**MODIFICATION REQUEST:  
Internal and External Design Changes  
and Amendment to Conditions to Dr  
Chau Chak Wing Building  
14-28 Ultimo Road, Ultimo  
(MP09\_0153 MOD 3)**

Director-General's  
Environmental Assessment Report  
Section 75W of the  
*Environmental Planning and Assessment Act 1979*

April 2013

TITLE
GROUND LEVEL
LANDSCAPE PLAN
HARD SURFACES

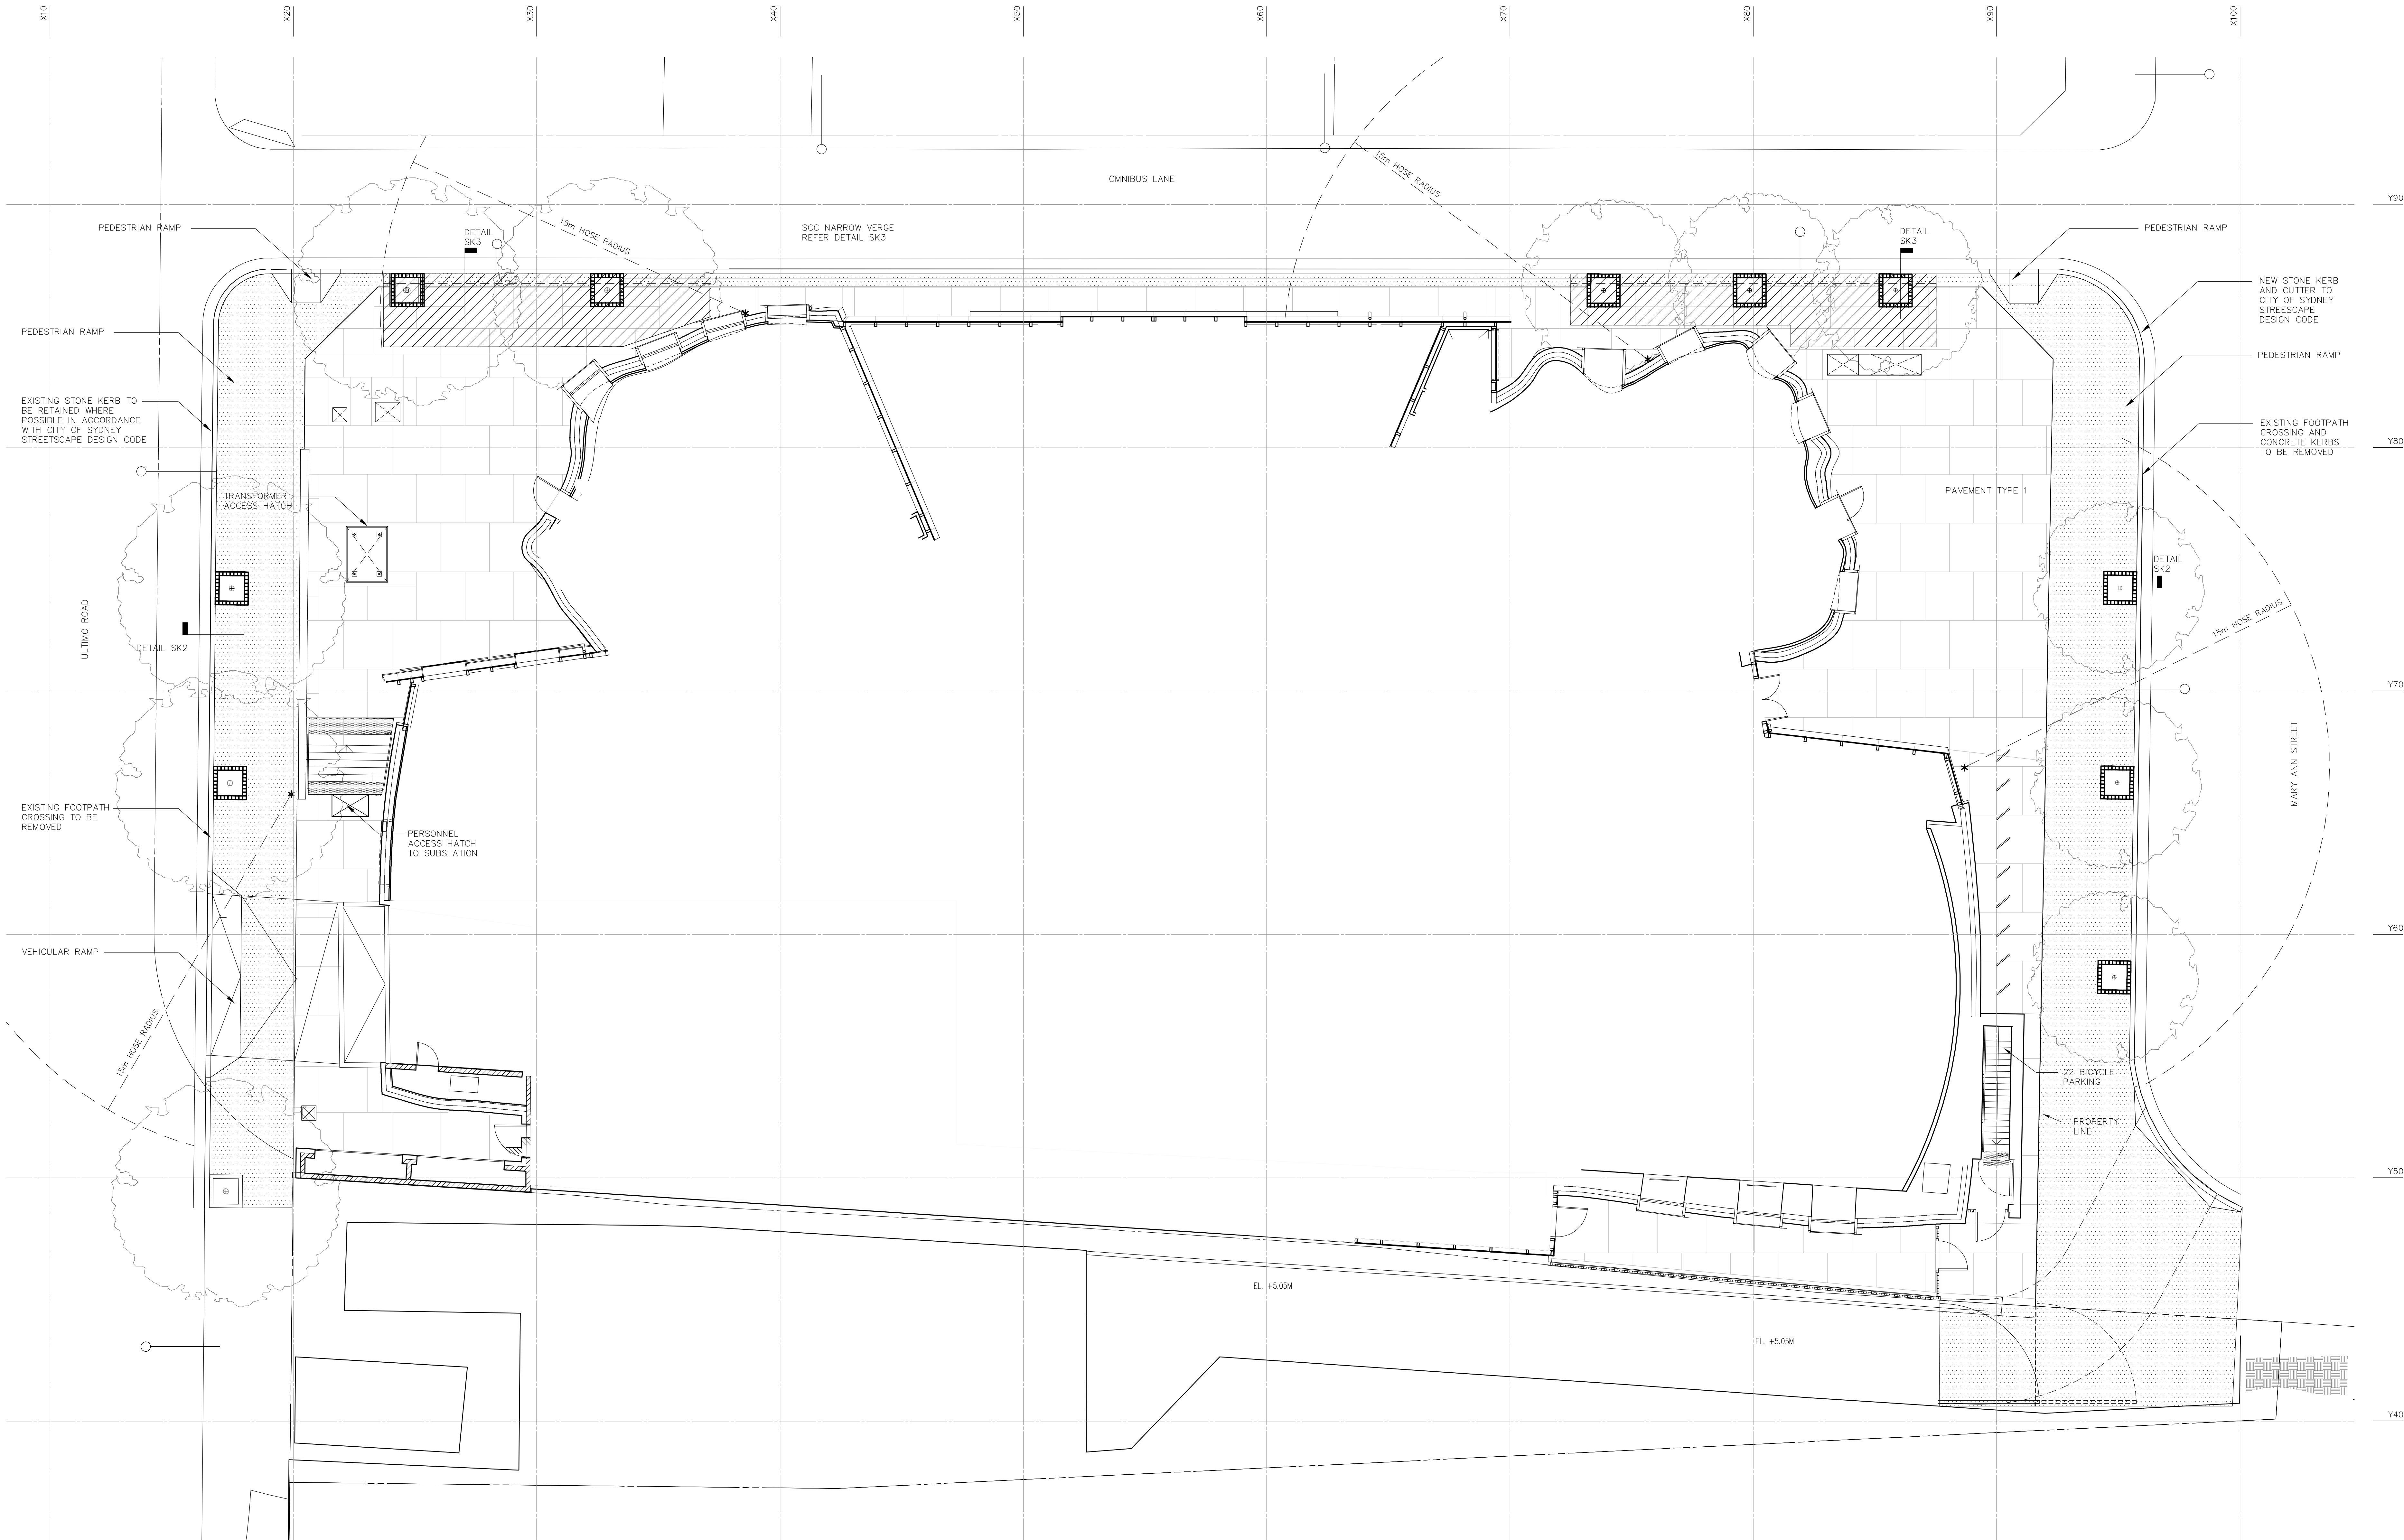
Council raised no objection to the proposed modifications. Notwithstanding, council requested that all stone setts around all trees be removed as they are only required when placed in granite paving, and therefore not necessary. The proponent has agreed to council's request.

The modification proposes to reduce the number of trees along the northern end of Omnibus Lane from four to three, to comply with council's request to allow a 6 metre separation between the trees. Council's submission confirmed the reduction in trees was required to allow sufficient spacing. The department considers this appropriate and it will not significantly alter the approved landscaping plan. In addition, council request the removal of all stone setts around all trees on site and on council land, as this detailing is no longer required by council. Accordingly, the department will condition the removal of all stone setts in the Instrument of Modification.

The proponent is seeking to replace the approved external asphalt pavers on ground level with cast in-situ concrete pavers, with a saw cut pattern in a natural concrete colour. This modification is pursued due to the unavailability of the approved material in Australia. The department considers the modification acceptable and the council has confirmed that it is consistent with the City of Sydney's Interim Sydney Street Design Code 2010.

TITLE
GROUND LEVEL
FLOOR PLAN

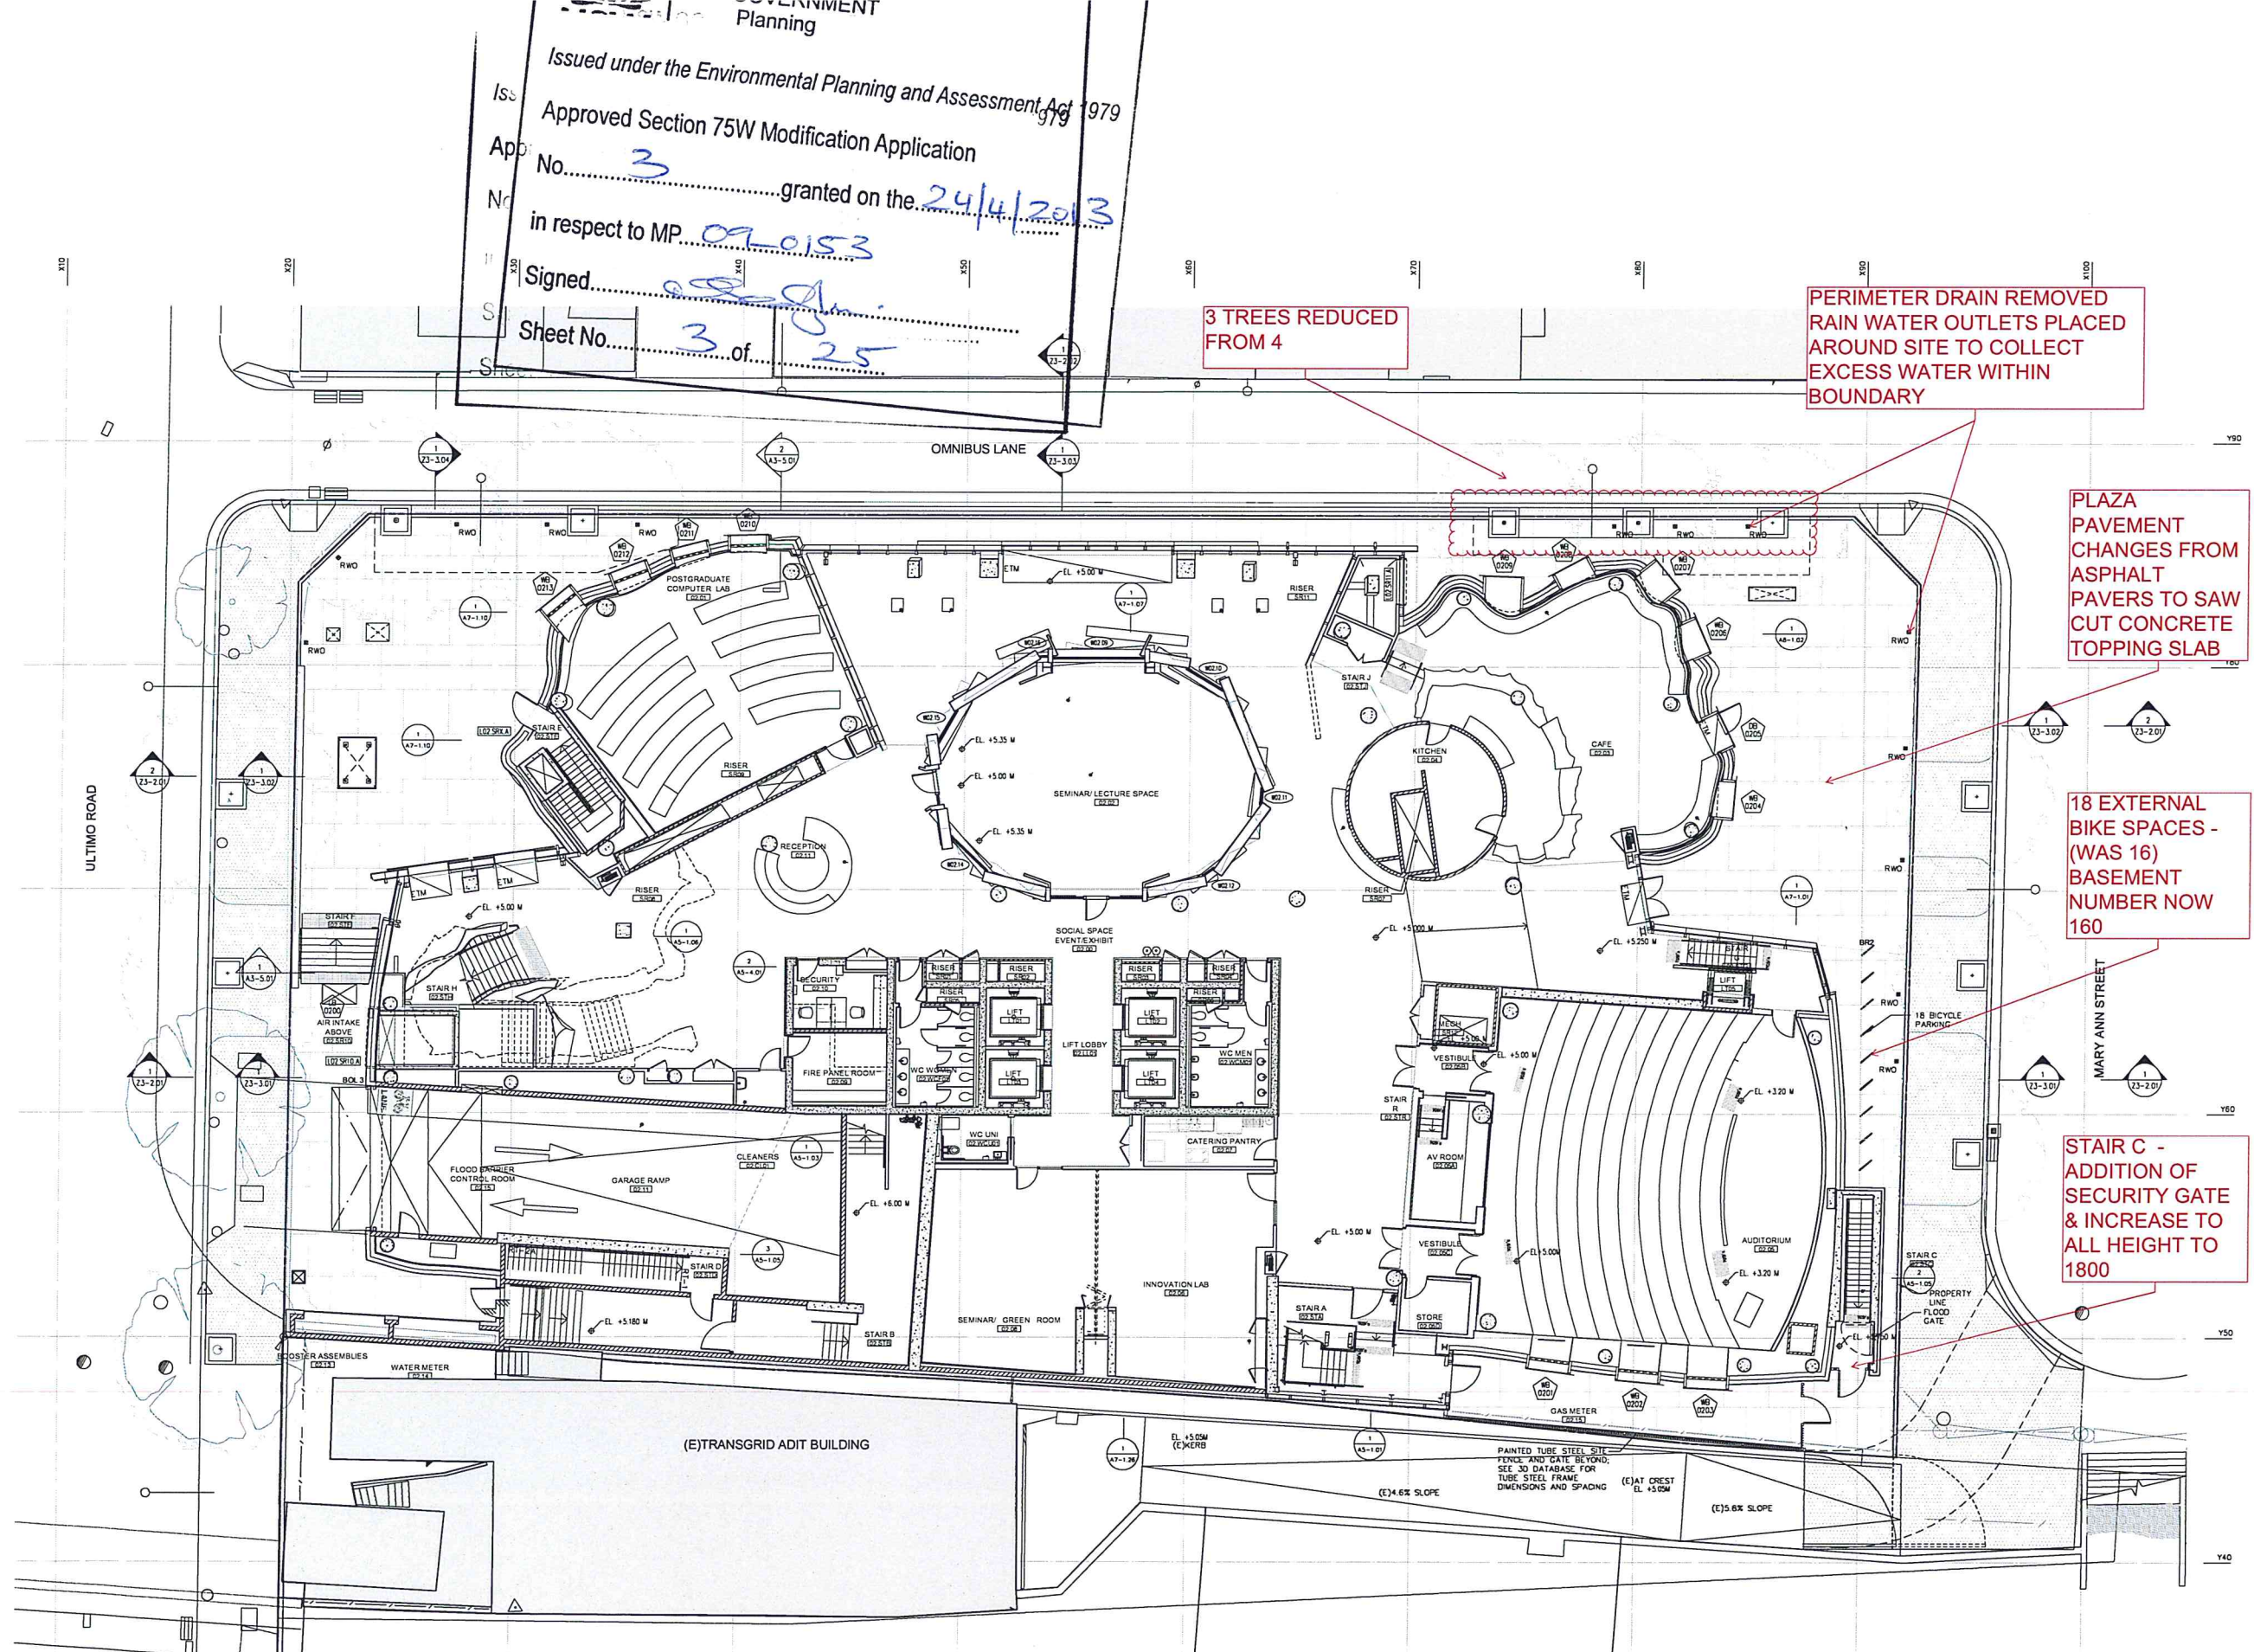
The modification application seeks to delete the perimeter stormwater drain on ground level due to potential blockages and trip hazards. Thirteen individual rainwater outlets are sought to be placed around the site in lieu of the perimeter drain to collect stormwater within the boundary.

One hundred and eighty seven bicycle parking spaces were approved under MOD 1, with 171 spaces within the basement and 16 on ground level. This was as result of minor reconfiguration of rooms within the basement which allowed extra bicycle spaces. The subject application proposes to decrease the number of bicycle spaces by 9, with 160 bicycle spaces available within the basement and 18 along Mary Ann Street. The department considers the proposed modification acceptable as it still exceeds the required amount that was approved in the original project application (177).

THIRTEENTH FLOOR
PLAN

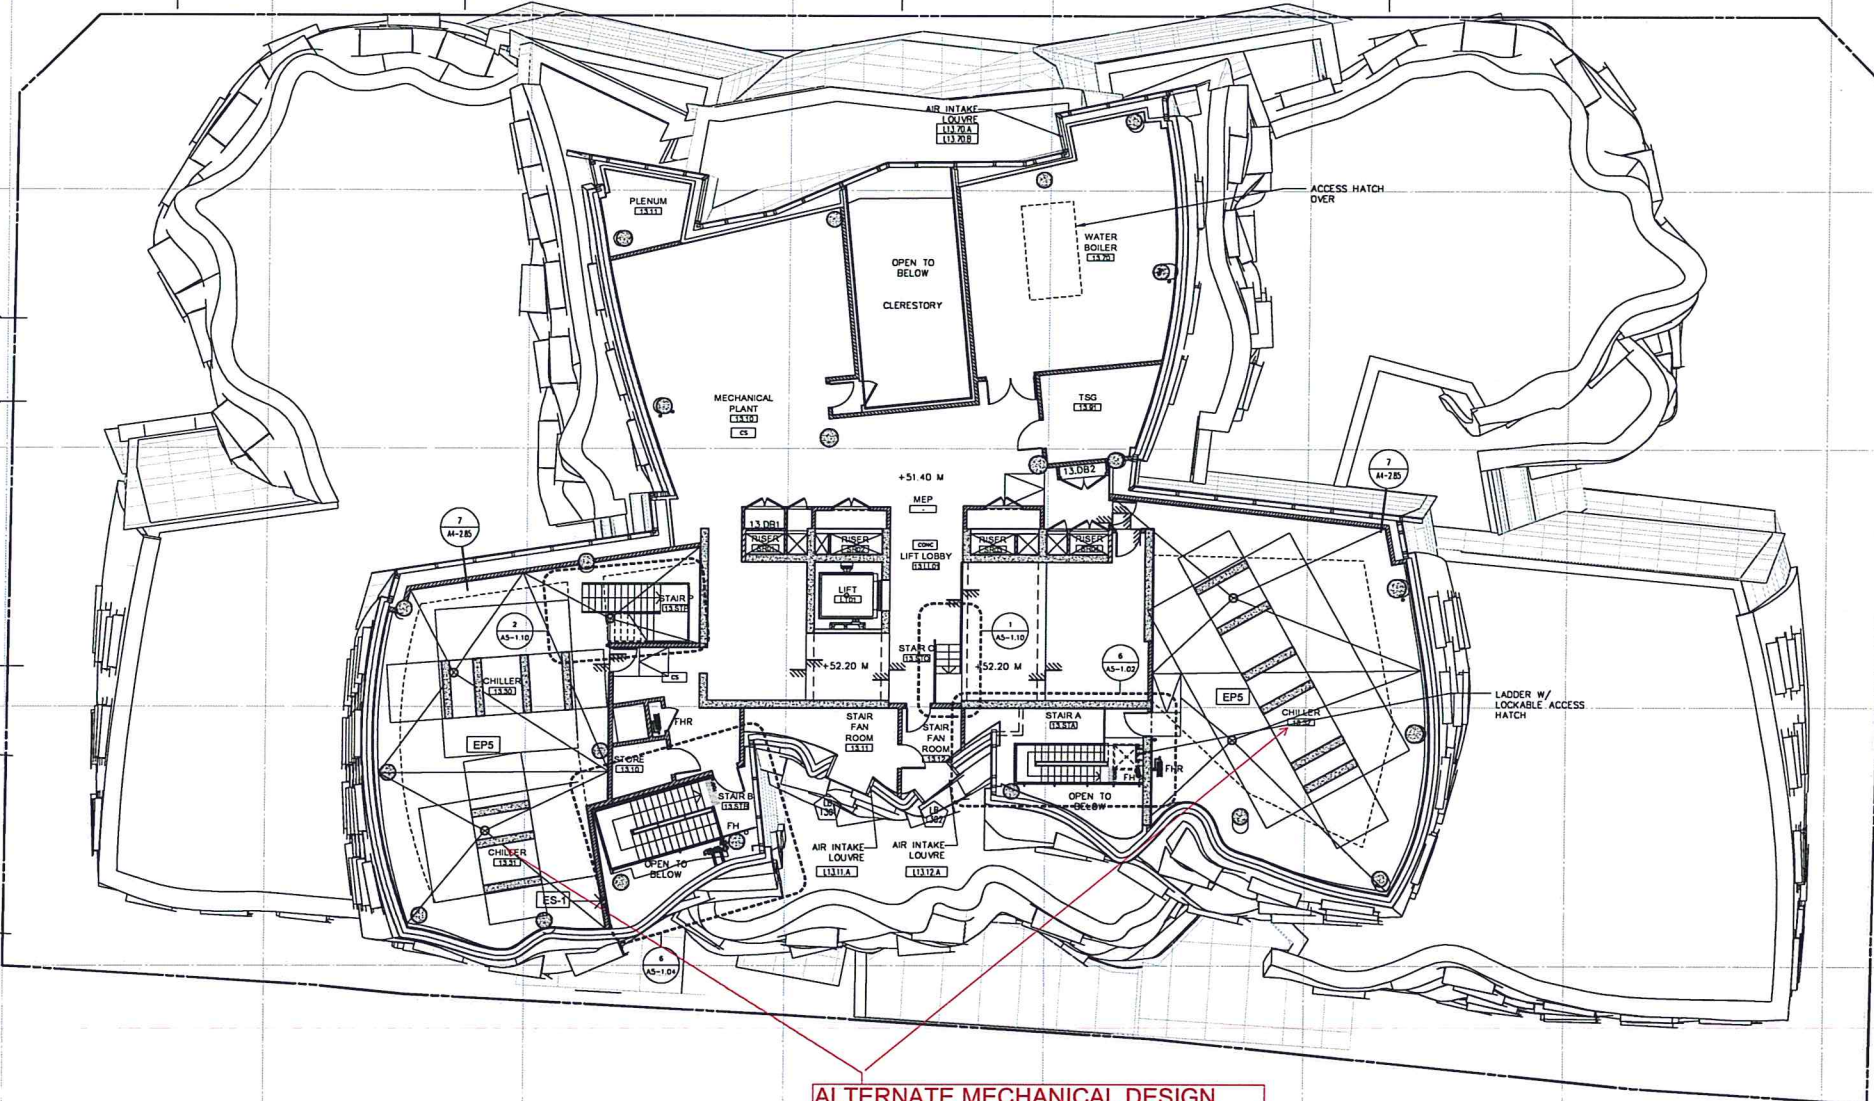
The original application implemented the tri-generation system and cooling tower as part of the building's ESD concept approach. MOD 3 seeks to substitute the tri-generation plant and cooling tower on level 13 with three air cooled chillers following an assessment of the engineering process. As a result, minor reconfiguration to the plant rooms are necessary to accommodate the air cooled chillers. Access to the roof via Stair P is to be relocated a few metres to the west and the mechanical plant relocated to the western portion of the building (see Figure 4).

The department considers the proposed modification is acceptable as it will maintain a 5 Star Green Star building rating. The reconfigurations to the plant rooms are minor in nature, would improve its functionality, and have no external visual amenity impacts. Accordingly, all conditions relating to the tri-generation plant (conditions E6 to E8, F10 to F15, and F19) will be deleted from the Instrument of Approval.
